KITTITAS COUNTY

MEMORANDUM

TO: Mackenzie Moynihan, CDS
FROM: Christina Wollman, Planner II *cw*
DATE: June 19, 2008
SUBJECT: Tiger Plat LP-08-22
Wildcat Plat LP-08-24
Additional Information Requested

MISSISSIPPI VIEW DRIVE

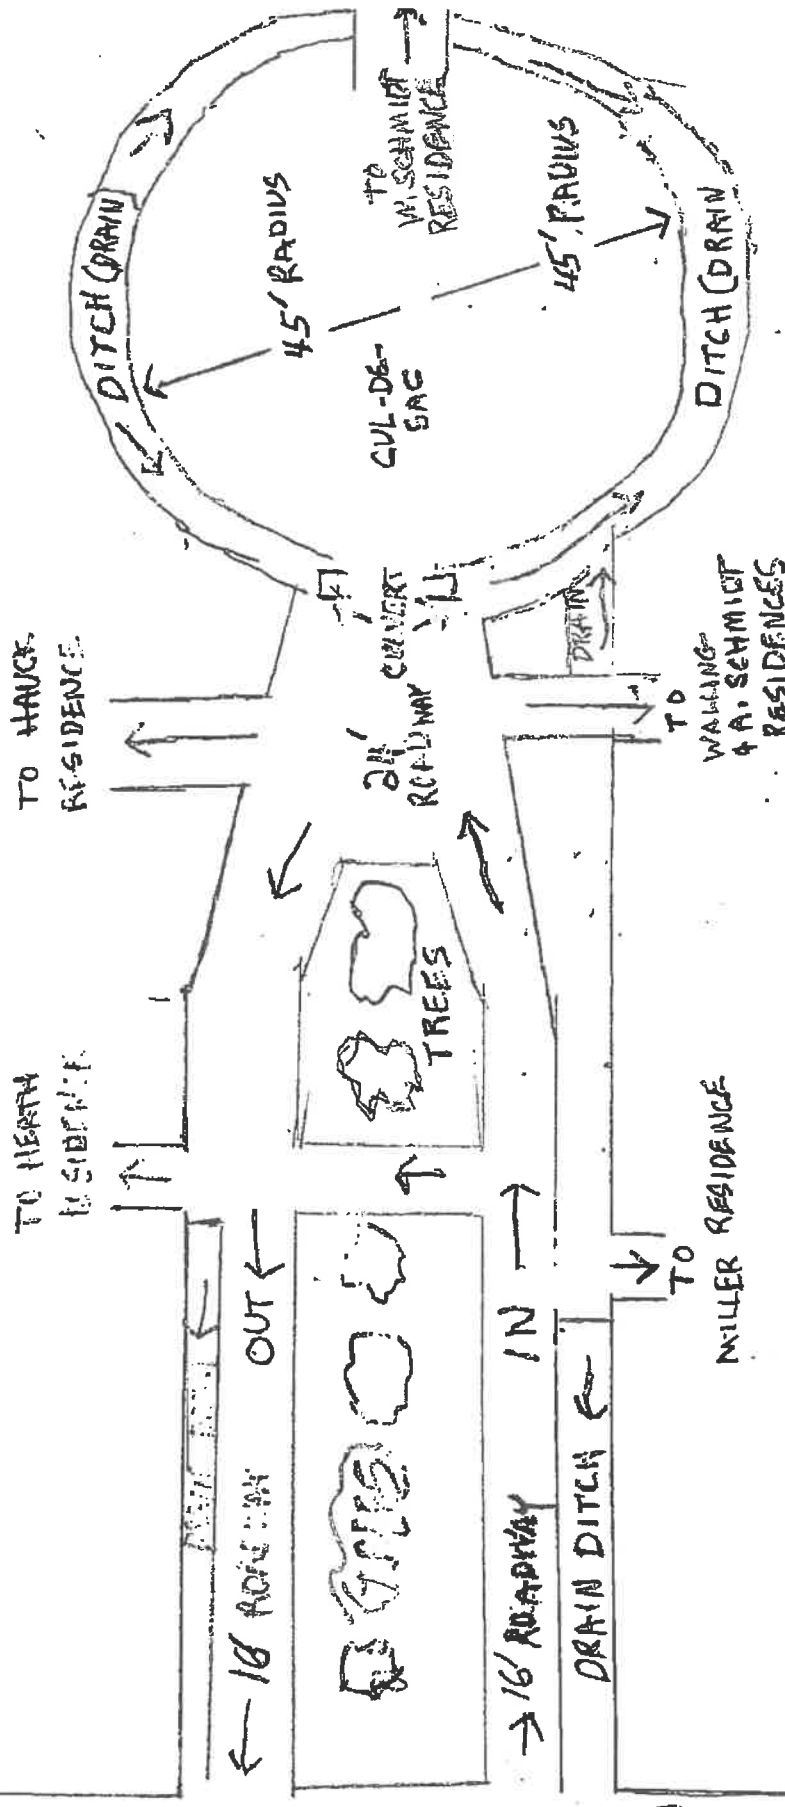
The Tiger and Wildcat Plats are accessed through Mission View Drive. A portion of Mission View Drive is constructed as 16' one way roads. Kittitas County Road Standards will require this private road to have a 24' total roadway width. The applicant will need to apply for a variance from this requirement. The variance must be approved prior to receiving conditional preliminary approval from Public Works.
